Address: 100 Redwood Drive Huddersfield HD2 1PW

Application number: 2023/90936	
What is the application for?:	Partial demolition and construction of new dwelling, detached garage and associa
Address of the site or building:	102, Redwood Drive, Bradley, Huddersfield, HD2 1PW
Postcode:	HD2 1PW

Type of comment: An objection	
Do you wish your comments to be published on the website anonymously?	No
We own and occupy 100 Redwood Drive and have a number of concerns about the application submitted in respect of 102 Redwood Drive. We also note, with disappointment, that the applicants failed to consult with us, as their next door neighbour, prior to submitting the application. Had they done so it might have avoided the need for us to make such strong objections which we set out below: The proposed scheme for No 102 shows an overbearing two storey extension which will extend the property on three sides, protruding from the rear wall of No 102 as it currently stands and raising the roofline by a substantial amount to the rear of the property. This will cause significant loss of light to our living accommodation at No 100, particularly impacting upon the roof lights which enable the living a

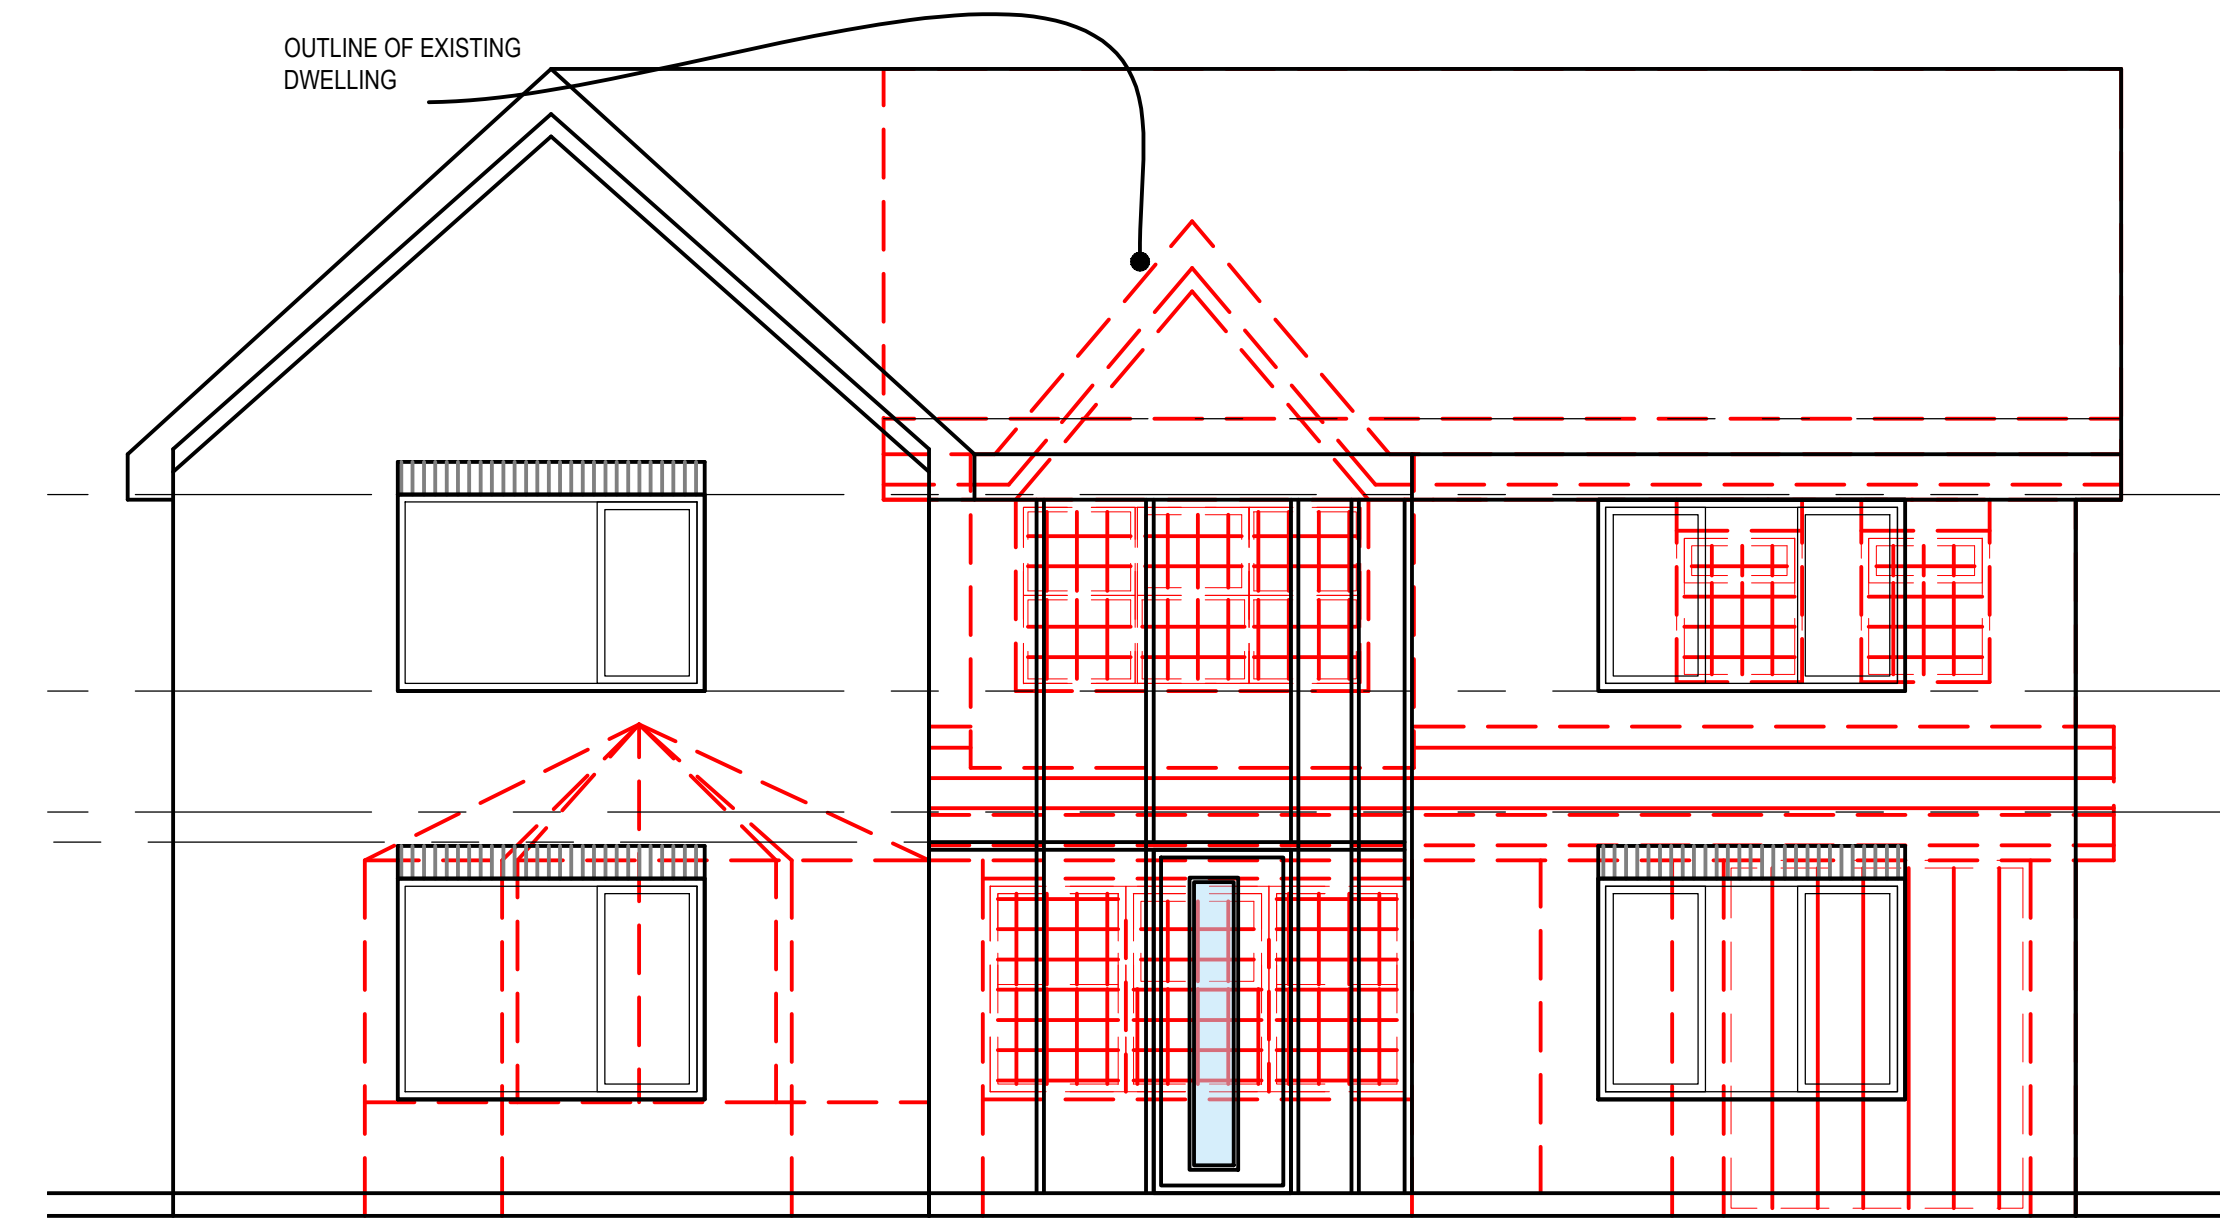
There are a number of well-established trees inside the garden and along the northern boundary of No 102 but the proposed site block plan does not indicate whether trees are being removed or retained.
